Sent: 29 August 2014 10:03
To: Janice Chapman
Subject: Planning Reference FP/132/14/HH

I saw planning at 10 Grafton Ave , reference FP/132/14/HH, I have open their planning and I am not happy as the car port is right on boundary line of my fence and adjacent to my property wall. The edge of the car port should be line with garage wall not boundary line.!!!!!!!!!!!!!!!!!!!!!!!!!!!!!!

FLOOR PLAN DRAWN AT 1:50 SCALE

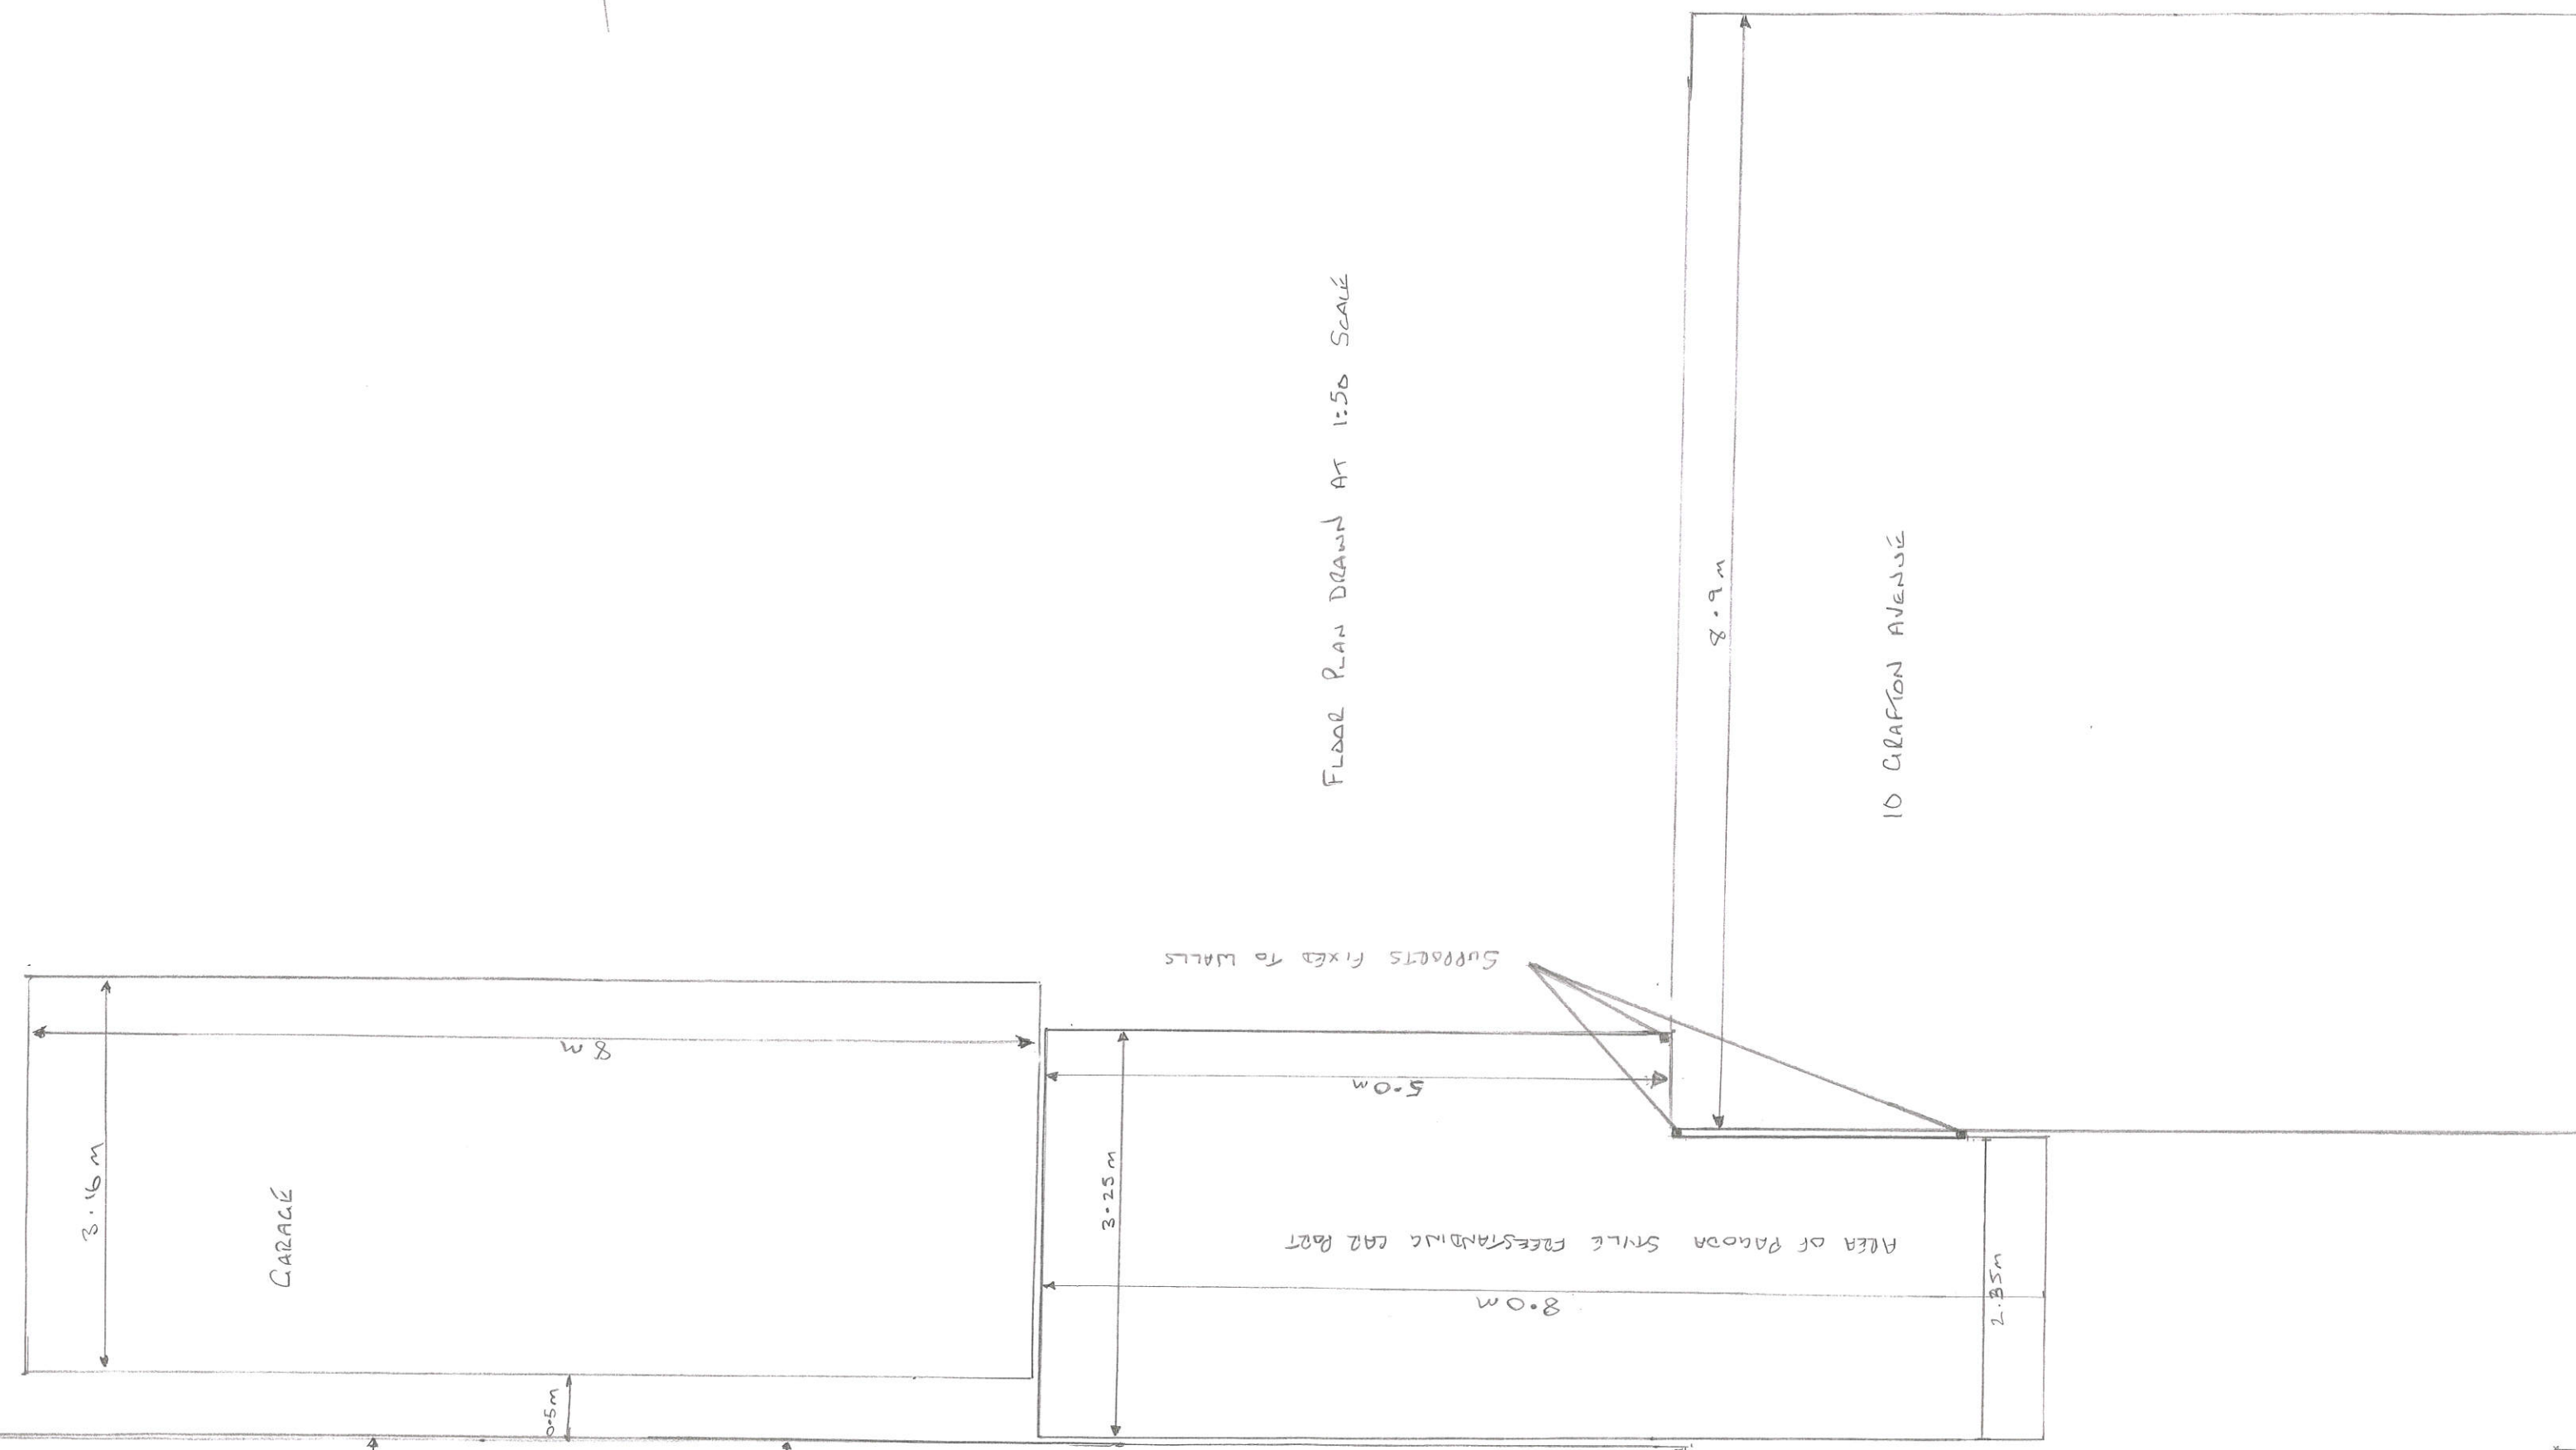
Also car port is longer toward from garage to adjacent of my property how can I access to my wall for future repairs which can be foul by ladder against car port.

What about the rain water flow to avoid over my boundary line and my property???????
